Kirklees Council
Planning and Development Service
PO Box 1720
Huddersfield
HD1 9EL

Date: 09/01/2025
Our Ref: 2022/93397

Highfields Centre, New North Road, Huddersfield, HD1 5LS

Application Number: 2022/93397

Drawing Title: Existing and Proposed Elevations Building A (3 of 4)

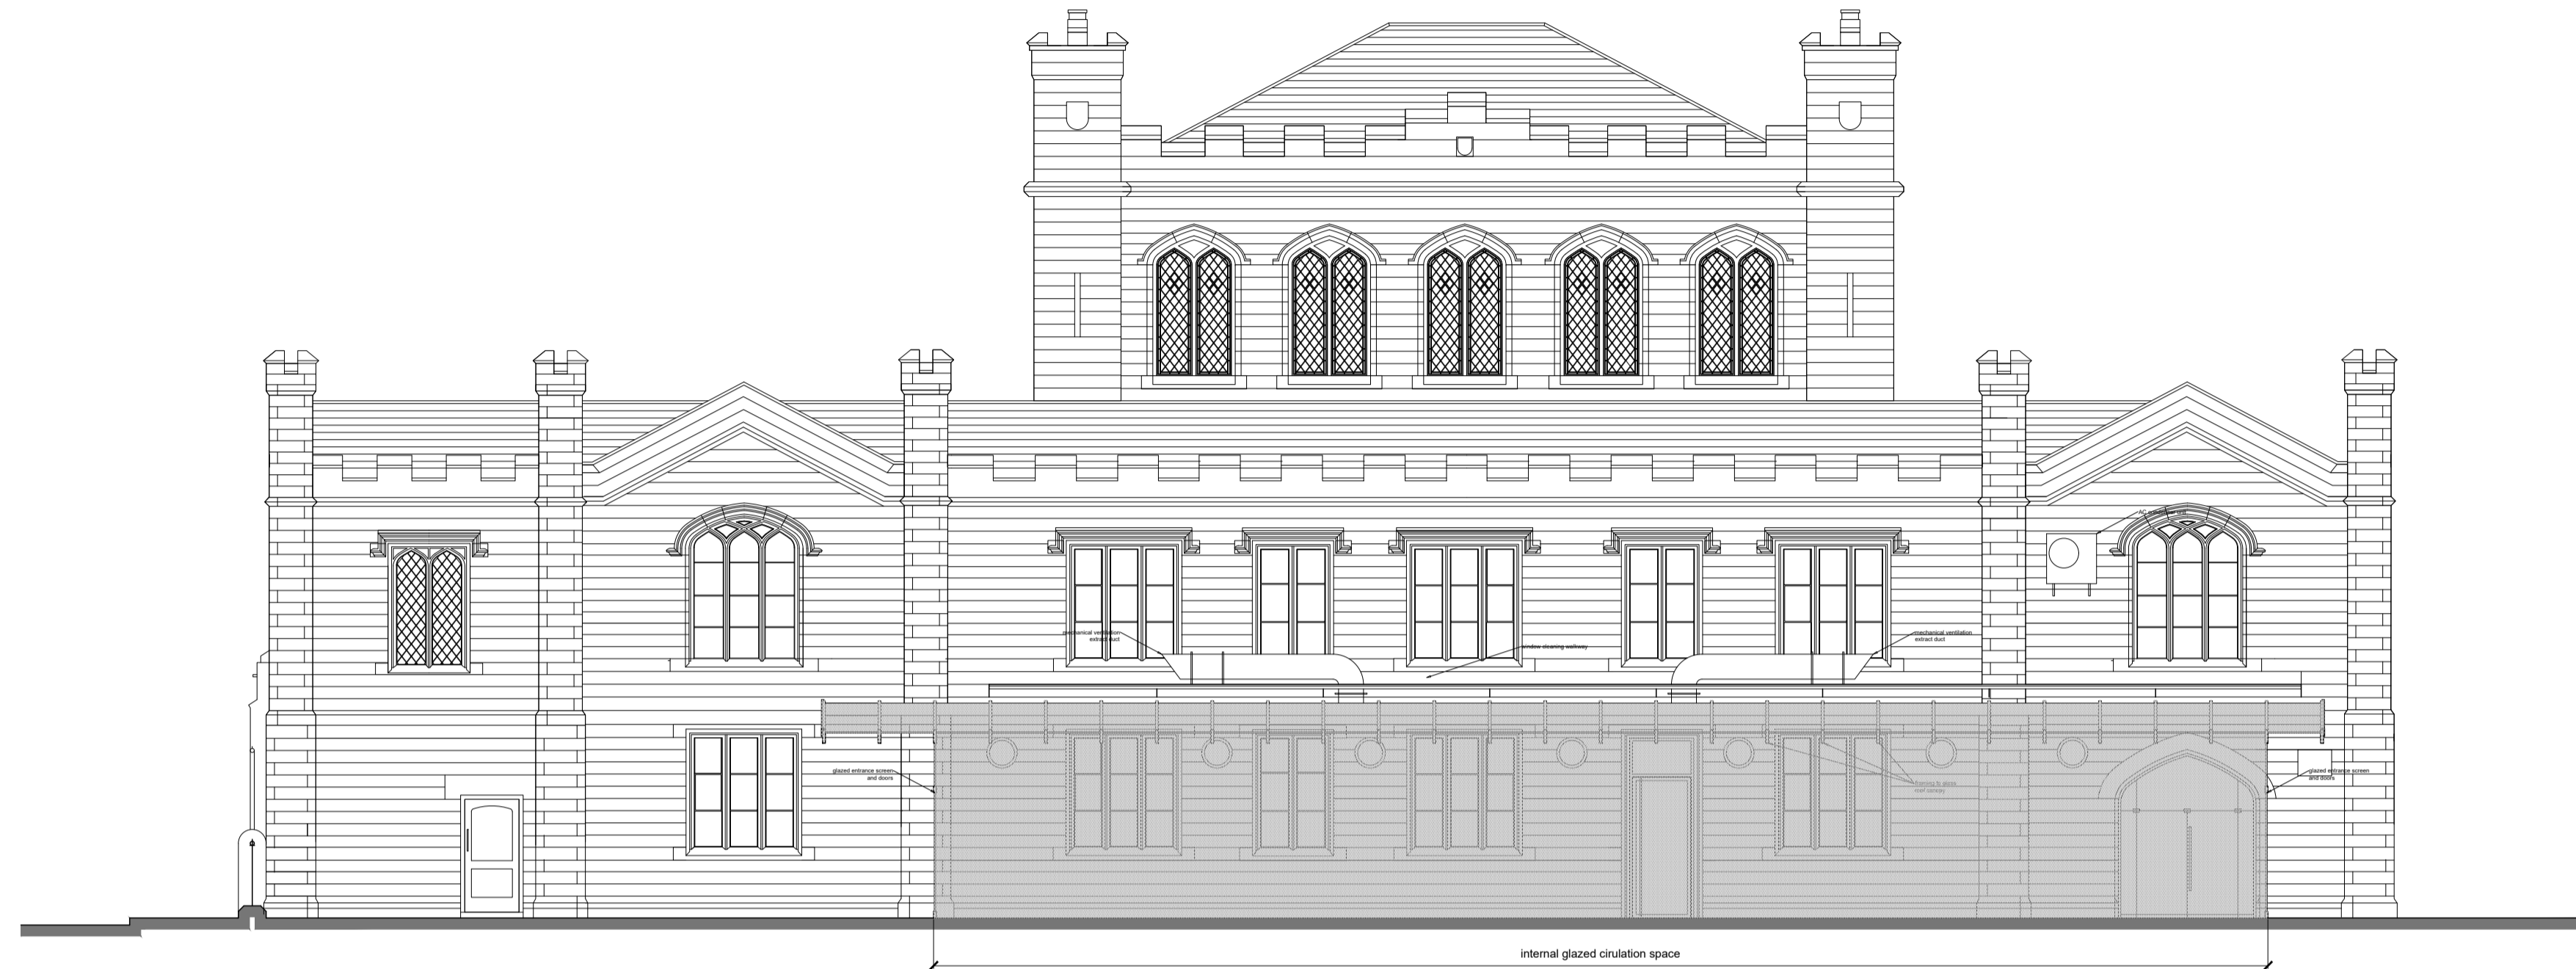
- Existing and Proposed Elevations – Building A (drawing 18.007(2-)011 rev B);
- Existing and Proposed Elevations – Building A (drawing 18.007(2-)012 rev C);
- Existing and Proposed Elevations – Building A (drawing 18.007(2-)013 rev C);
- Proposed Elevations – New Link and Link Tower, Existing and Proposed Elevations – Former Toilet Block (drawing 18.007(2-)014 rev E); and
- Existing and Proposed Elevations – Building B (drawing 18.007(2-)015 rev B)

Notwithstanding the above list, it is noted that drawing 18.007(2-)014 rev E does not, in fact, show any external lighting.

The submitted drawings indicate where four types of external lighting fitting would be installed or retained. The four types are described on the submitted drawings as follows:

- Decorative wall-mounted fitting, approximately 300mm diameter, opal diffuser;
- Existing floodlight;
- Decorative traditional style lantern; and
- Combined uplighter/downlighter, stainless steel cylindrical fitting, approximately 70mm x 250mm.

While the locations and numbers of the proposed and retained light fittings are considered acceptable, an approval pursuant to condition 11 cannot be issued at this stage, as no details (in the form of product specifications for the proposed fittings, and photographs of the fittings to be retained) have been submitted. Furthermore, the documents listed in your letter of 29/05/2024 have not identified areas or features within or adjacent to the development that are visited by bats, and where external lighting may cause disturbance to bat breeding, resting or foraging places or to important routes used by bats to access key areas of their territory.

Drawing Title: Existing Plans Building A

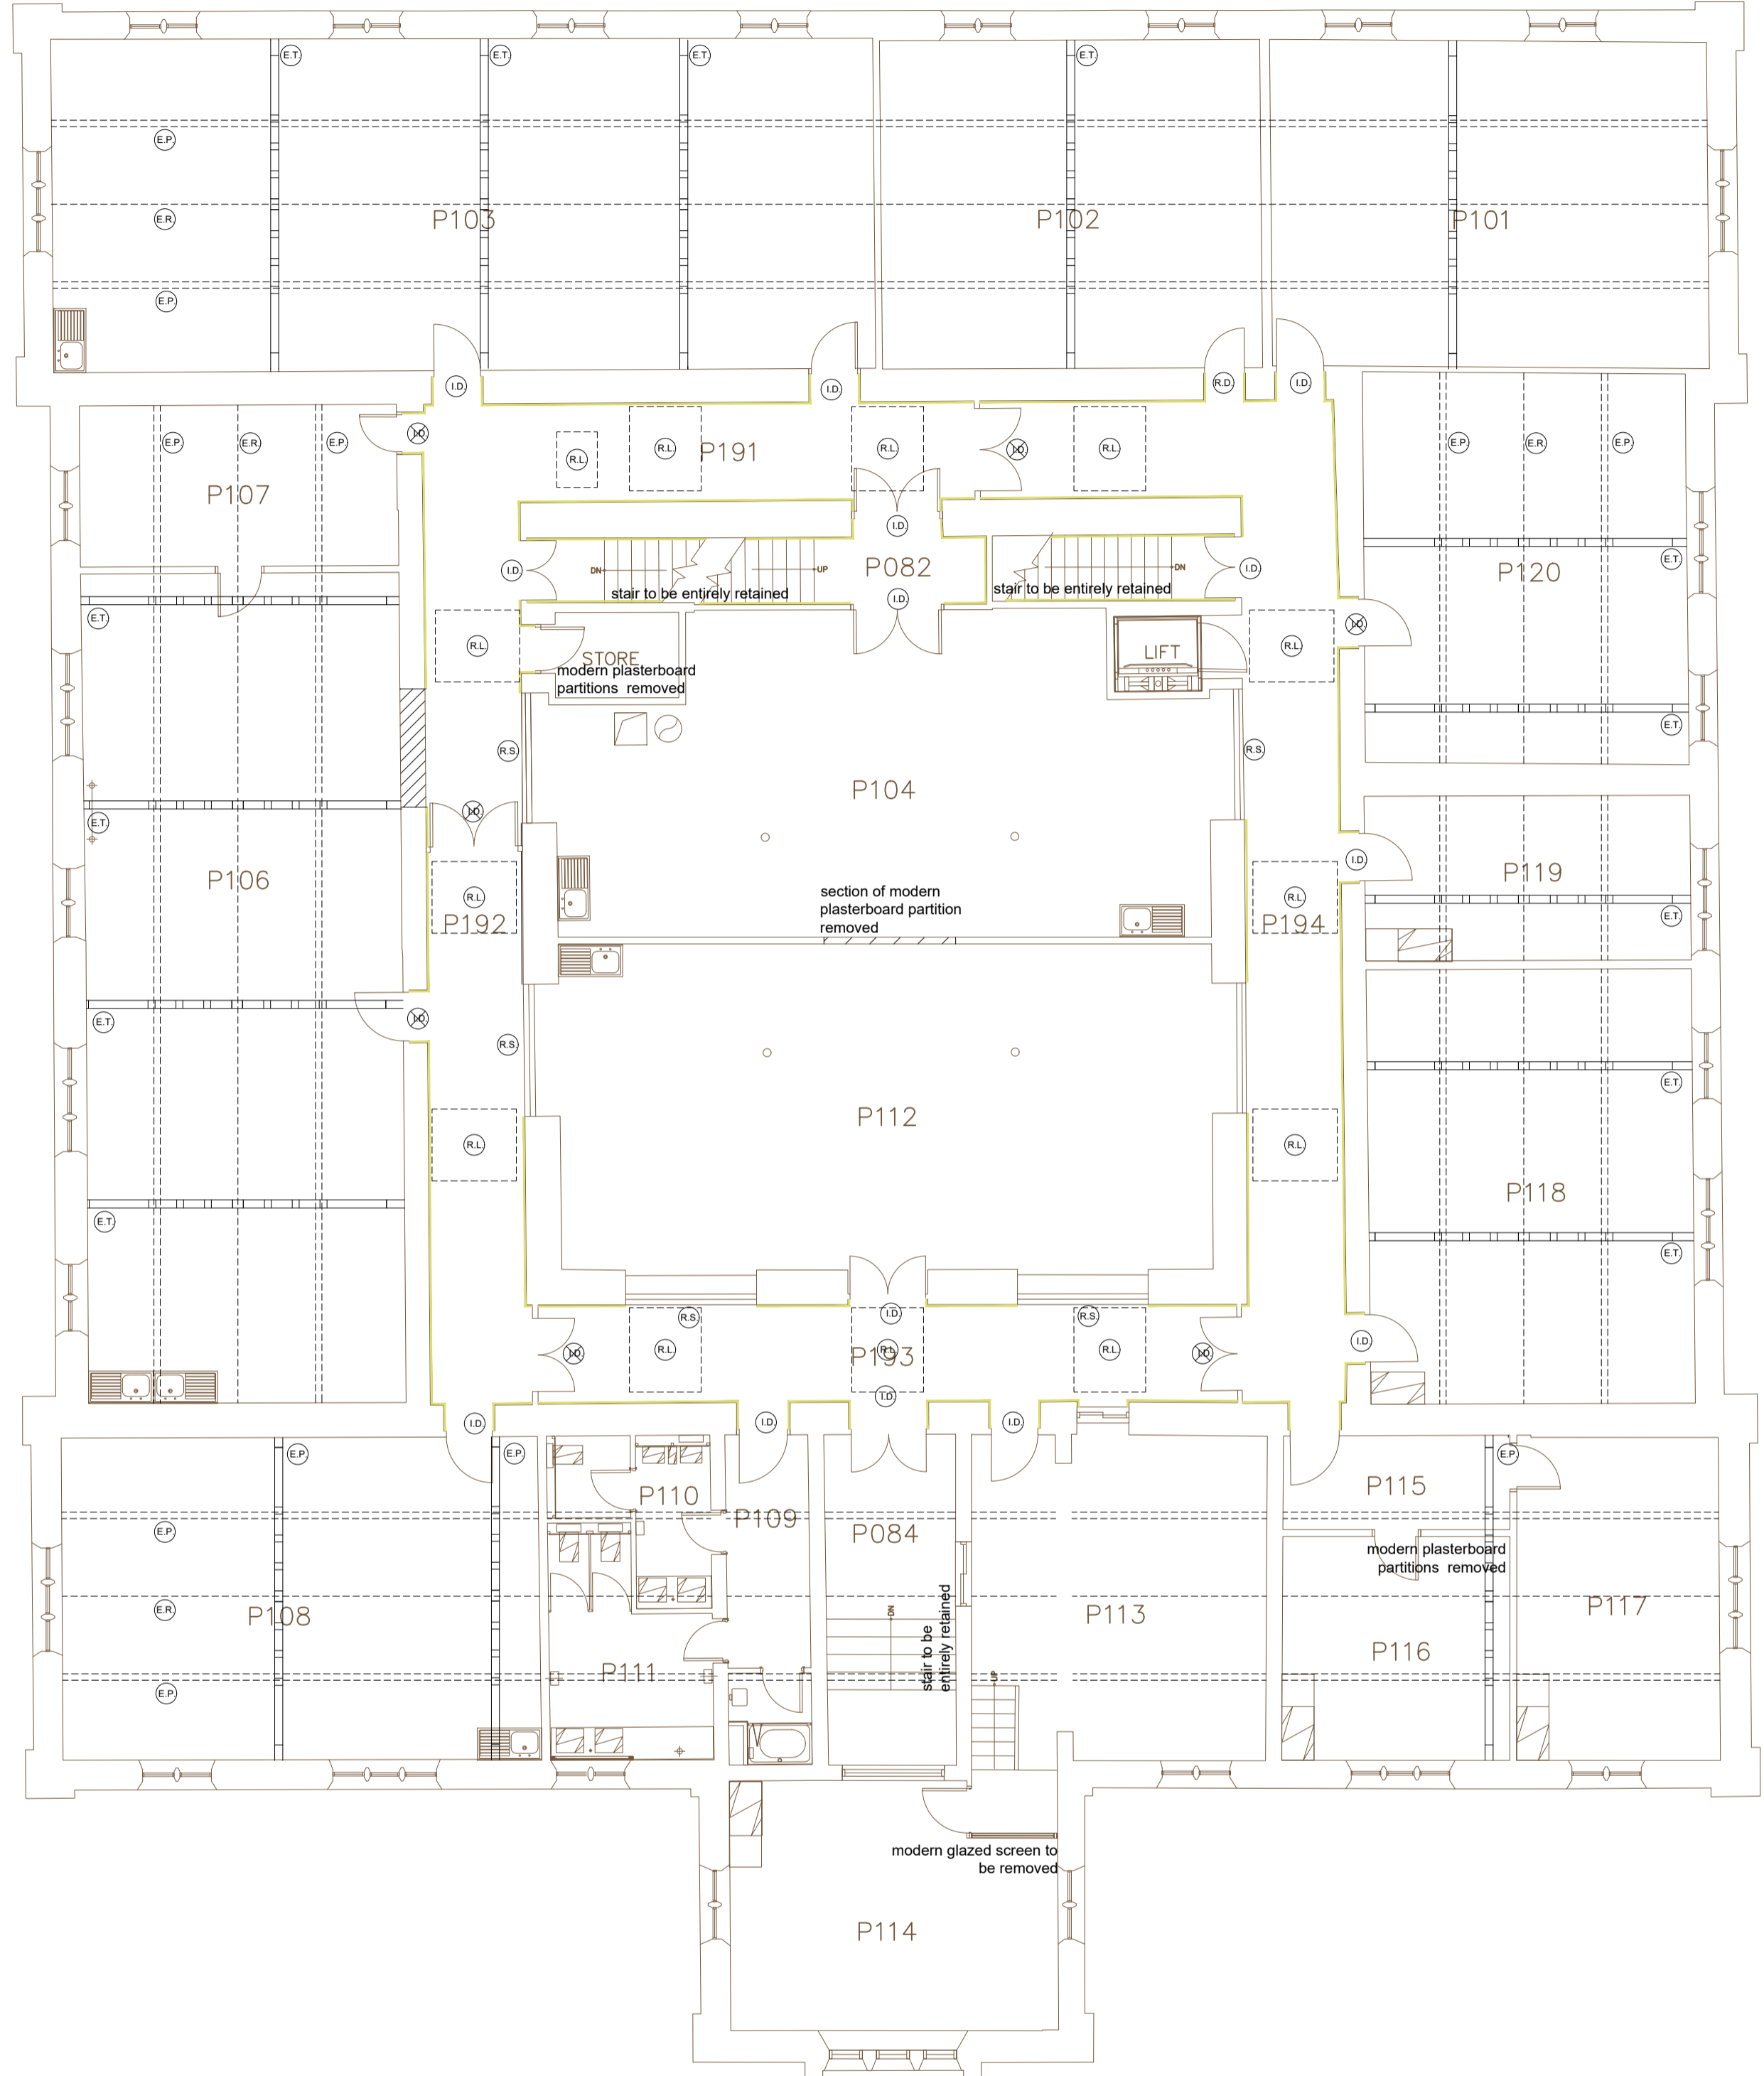
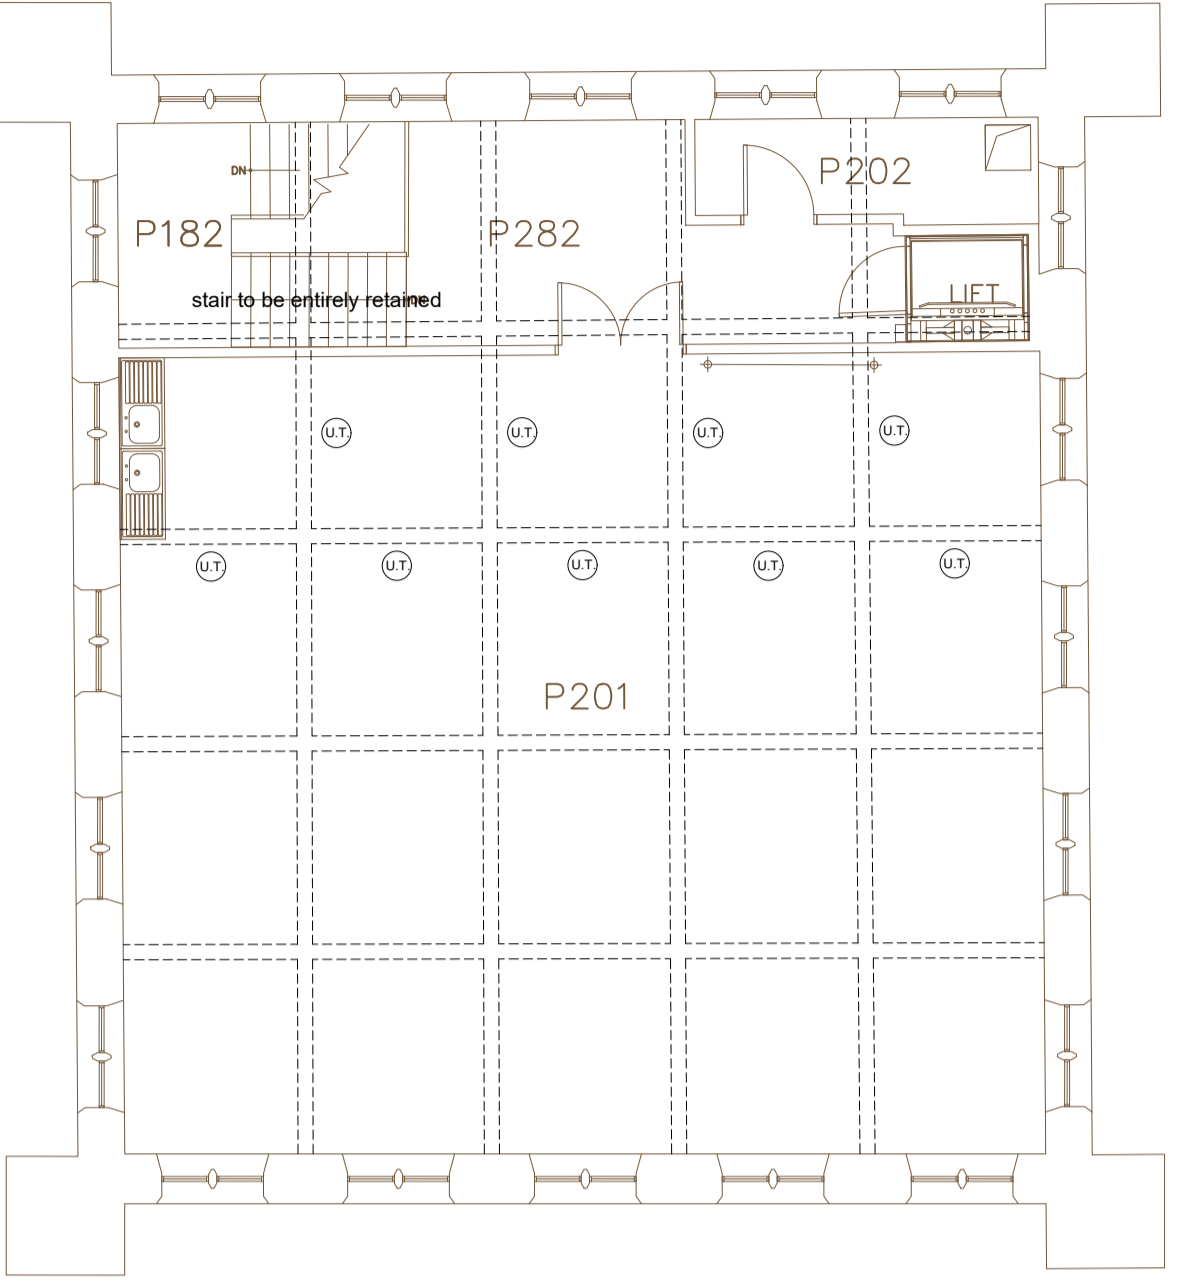
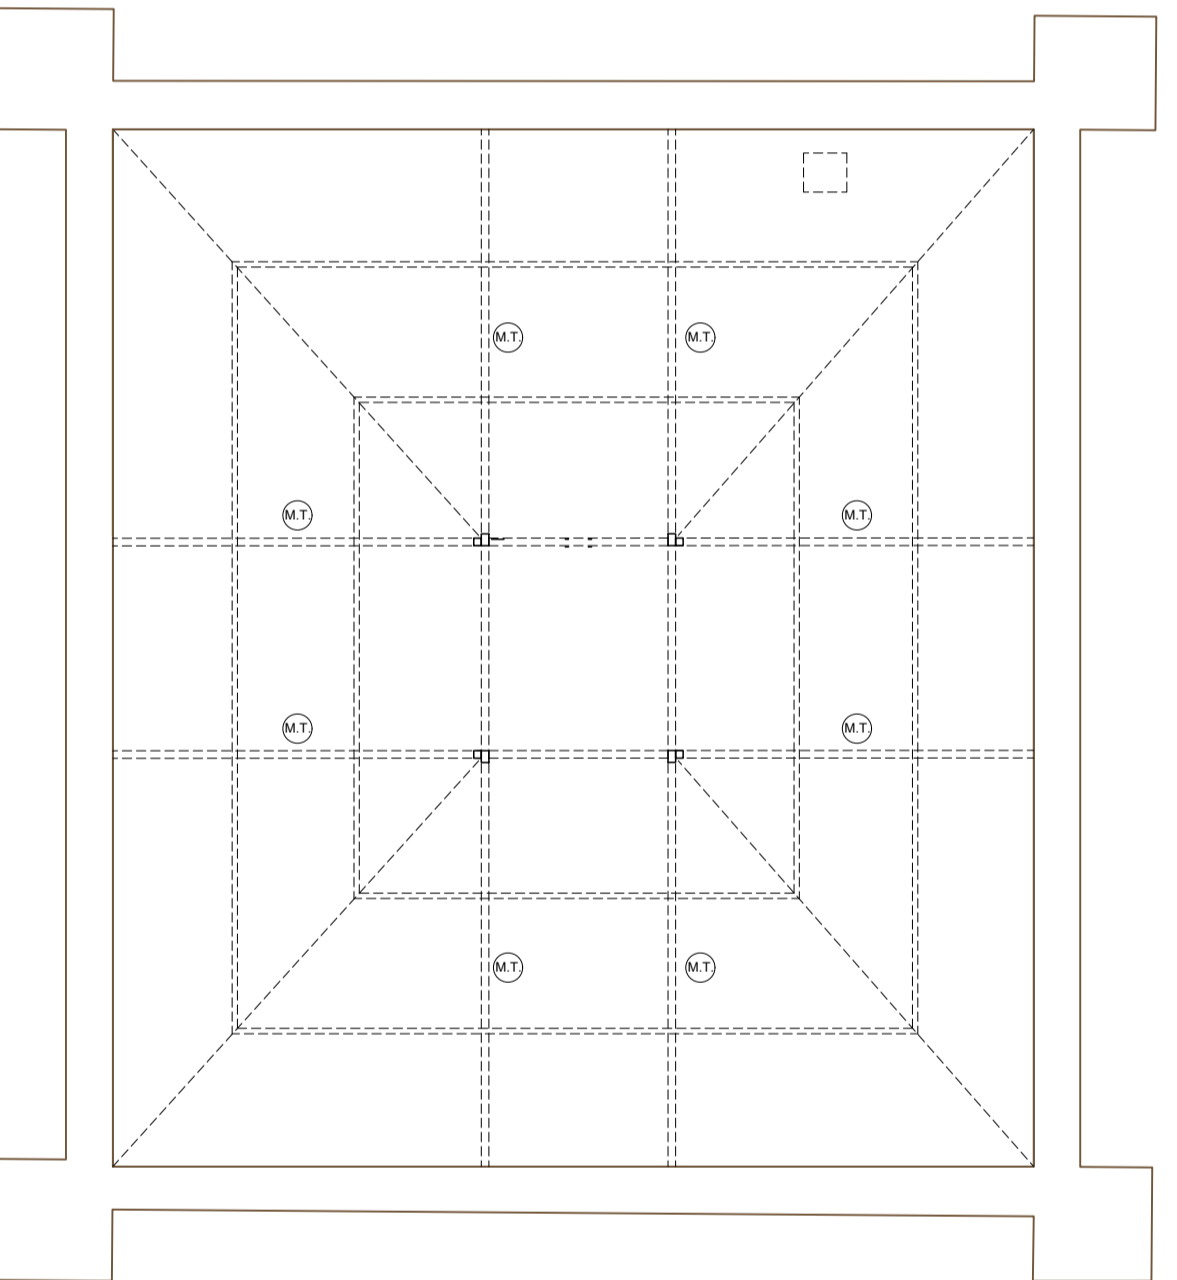
- Window and External Door Schedule (10.01.004 window schedule);
- Proposed Ground Floor Plan: Building A and toilet block and all floors: Link and Tower Buildings (drawing 18.007(2-001 rev G);
- Proposed First Floor and Mezzanine above First Floor Plans: Building A (drawing 18.007(2-002 rev C);
- Proposed Second Floor and Mezzanine above Second Floor Plans: Building A (drawing 18.007(2-003 rev E);
- Existing Plans Building A (drawing 18.007(2-016 rev B);
- Existing Plans Building A (drawing 18.007(2-017 rev B);

Figure 1 – Noise measurement position(s)

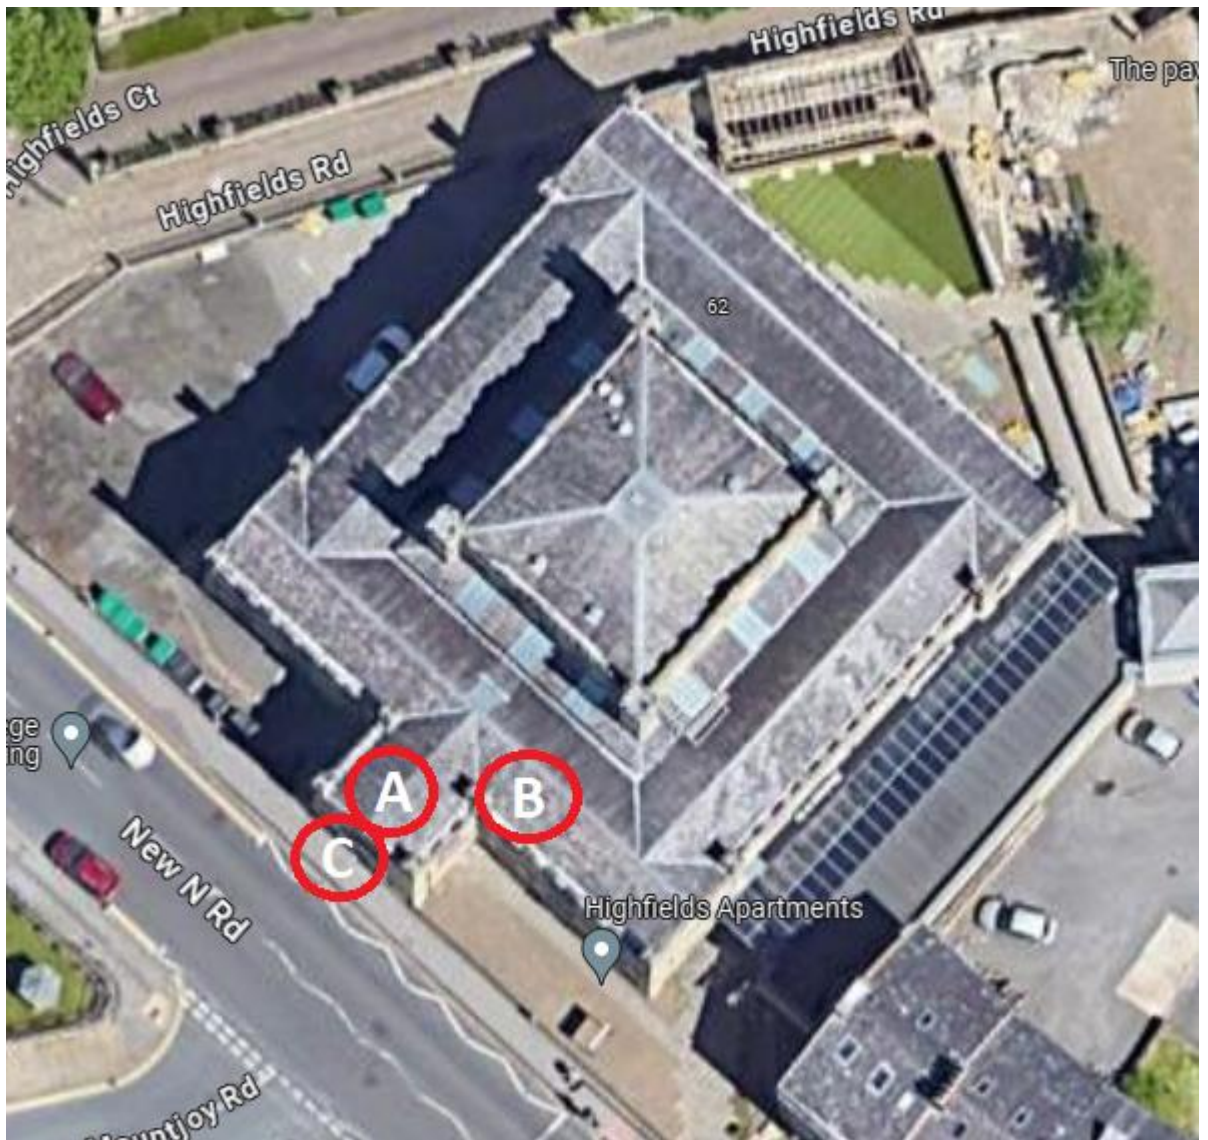
Paragraph 1.1 of the submitted document refers to secondary glazing, indicating that this has been installed at apartment F.8 in building A, however this is not shown on drawing 18.007(2-)002 rev C. In fact, the drawings submitted pursuant to condition 9 indicate that secondary glazing is to be installed only to one window (serving the bedroom of apartment G.6, as shown in drawing 18.007(2-)001 rev G). The Window and External Door Schedule
